April 21, 2023

**Re: Allaso Journal Center**  
**7800 Headline Blvd NE**  
**Request for Certificate of Occupancy**  
**Transportation Development Final Inspection**  
Engineer's/Architect's Stamp dated 07-13-20 (D17-D107)  
Certification dated 04-03-23

Based upon the information provided in your submittal received 04-03-23, Transportation Development cannot approve the release of Certificate of Occupancy for the above referenced project.

A1.10
SITE PLAN

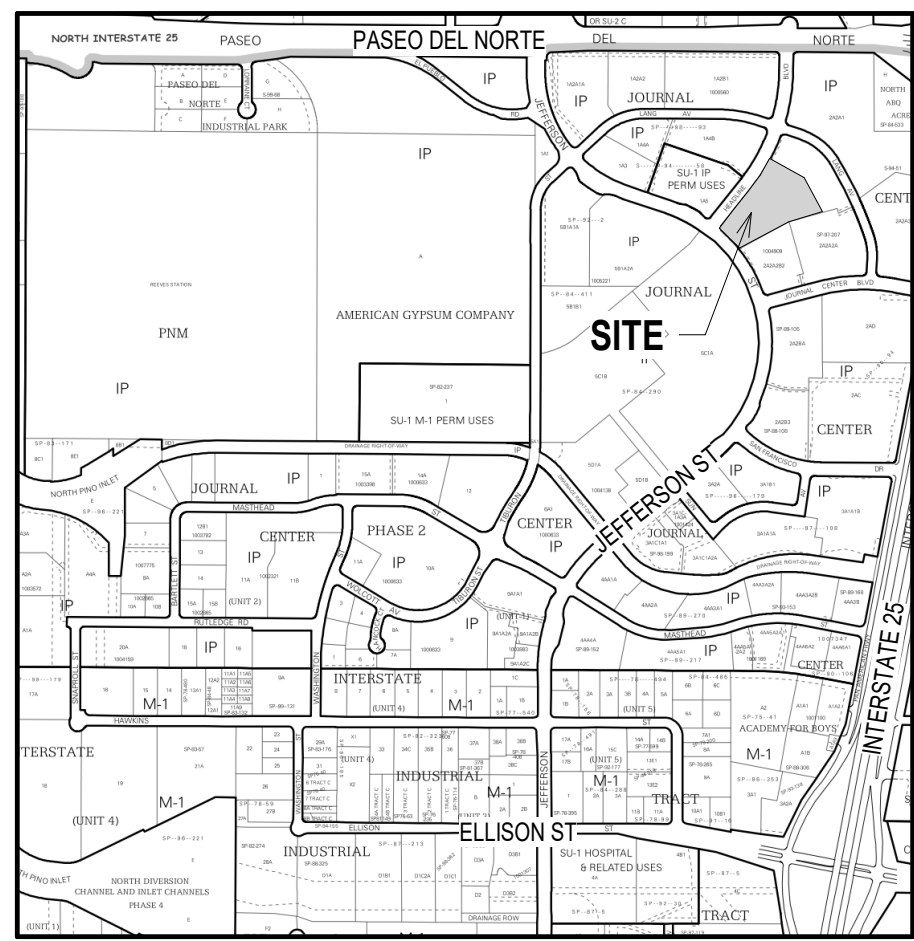
- Plastic covers over truncated domes need to be removed
- Construction along sidewalks need to be completed
- Striping and accessible curb on NE corner needs to be built as specified in Site Plan (see Below)

- The provided parking calculations shows 6 ADA parking spaces. The site plan shows only 5 ADA parking spaces. Please clarify.

- Upon site inspection ADA marked parking space (not on plan) is only 8' wide. Minimum ADA parking stall width is 8.5'. See below for location.
